Rezoning Transportation Analysis

Petition Number: #2022-081

Date	Description
11-03-2022	First Review (PDM)

REZONING PLAN

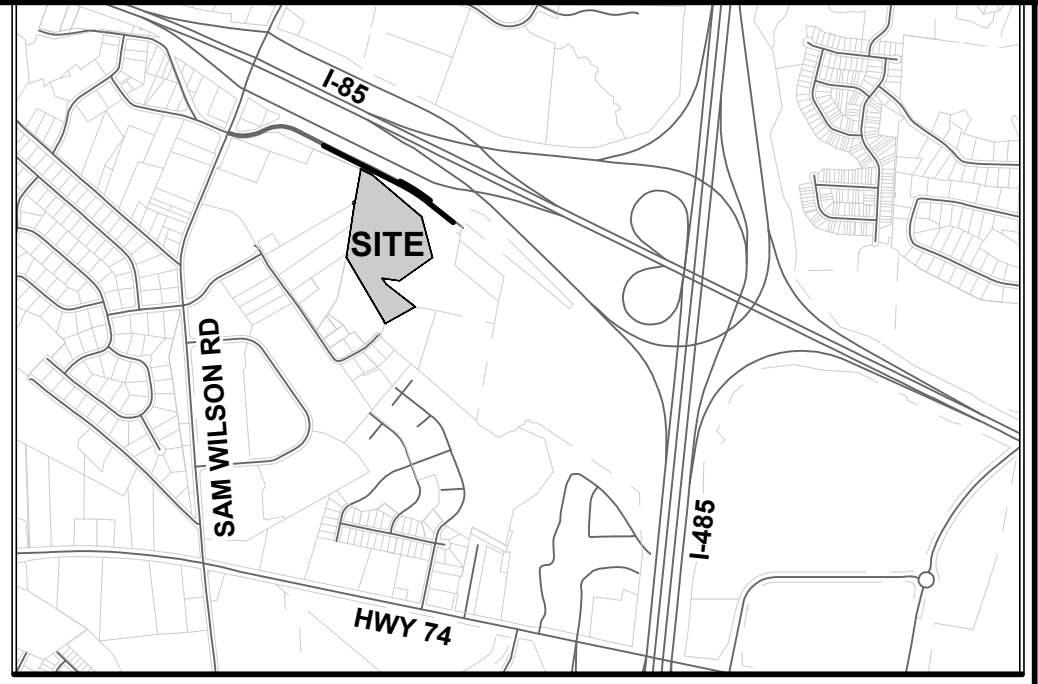
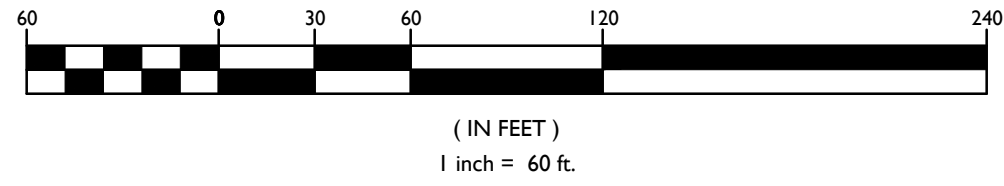
- Per coordination with NCDOT, revise site plan and conditional notes to commit to improving the existing road on I-85 Service Road to NCDOT standards along the property frontage.

- A site plan note(s) specifying dedication and fee simple conveyance of all rights-of-way to the City before the site's first building certificate of occupancy is issued as needed. CDOT requests rights-of-way set at 2' behind back of sidewalk where feasible.

- A site plan note specifying that all transportation improvements will be approved and constructed before the site's first building certificate of occupancy is issued as needed. The petitioner may phase transportation improvements if said improvements and phasing are explicitly described in site plan notes.

- Add conditional note "All public roadway improvements will be subject to the standards and criteria of CDOT and NCDOT, as applicable, to the roadway improvements within their respective road system authority. It is understood that such improvements may be undertaken by the Petitioner on its own or in conjunction with other development or roadway projects taking place within the broad western Mecklenburg area, by way of a private/public partnership effort or other public sector project support."
